Re: Planning Application 21/0098

Address: Lea Barn Four Acre Lane Preston

Description: Proposed conversion of a barn to a residential dwelling and associated works.

Proposed & Existing Site Plan
& Location Plan

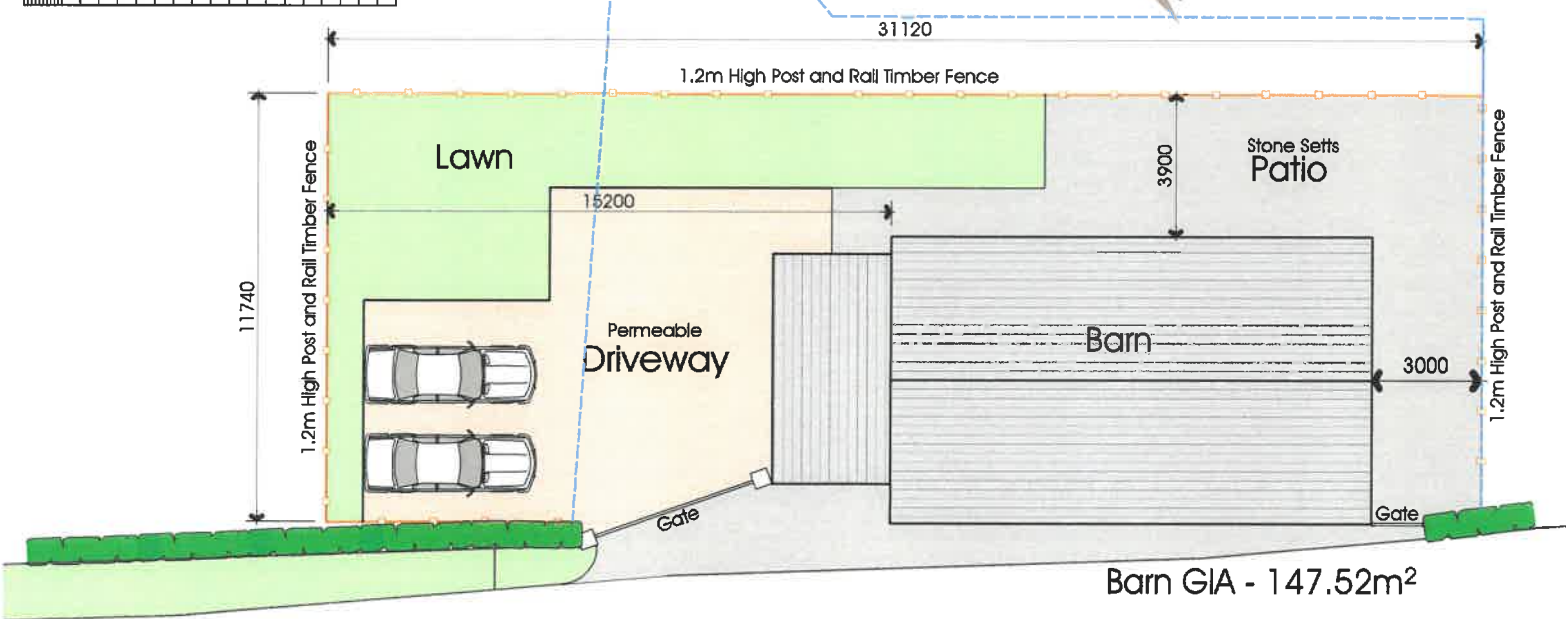
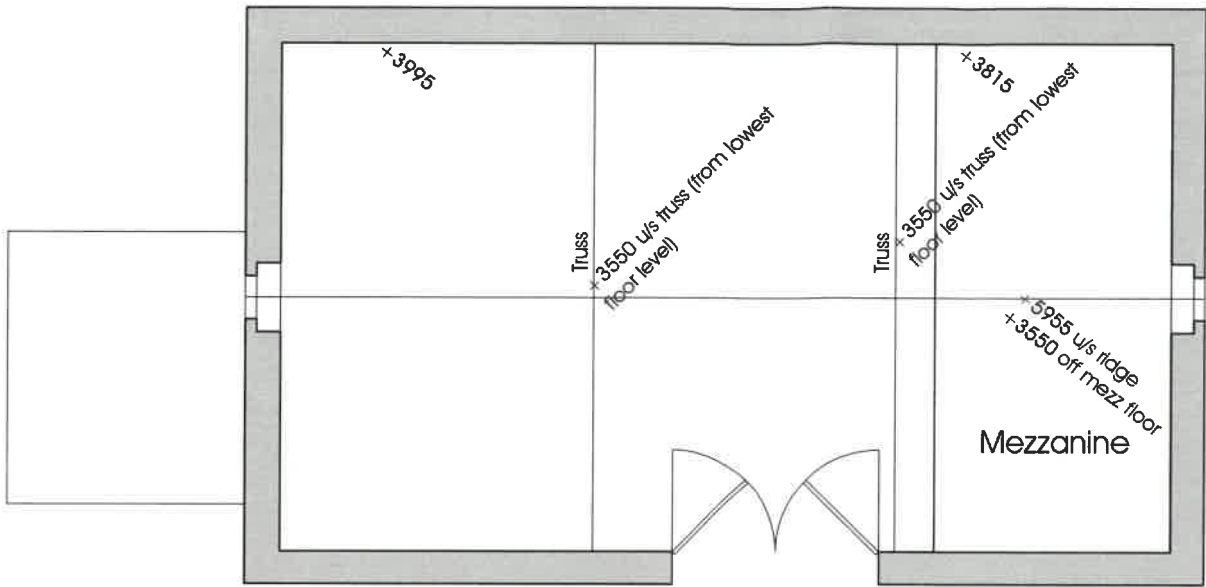
However there are concerns regarding the access and the location of the gates. It is expected that the gate posts should be positioned 5m behind the edge of the carriageway to allow a vehicles to pull clear of the carriageway.

A plan showing the available sight lines measured 2.4m back from the edge of the carriageway should be provided.

Construction details of the treatment of the proposed hardstanding between the edge of the carriageway and the barn wall including the gated access will be required. Our records indicate that this area forms part of the adopted highway, in order to form the revised access a Section 278 Agreement will be required.

Before the access is used for vehicular purposes, any gateposts erected at the access shall be positioned 5m behind the nearside edge of the highway and visibility splay fences or walls shall be erected from the gateposts to the existing highway boundary, such splays shall be 45° to the centre line of the access. The gates shall open away from the highway. Should the access remain un-gated 45° splays shall be provided between the highway boundary and points on either side of the drive measured 5m back from the nearside edge of the highway.

Before the access is used for vehicular purposes, that part of the access extending from the highway boundary for a minimum distance of 5m into the site shall be appropriately paved in tarmacadam, concrete, block pavements, or other hard material to be approved by the Local Planning Authority.
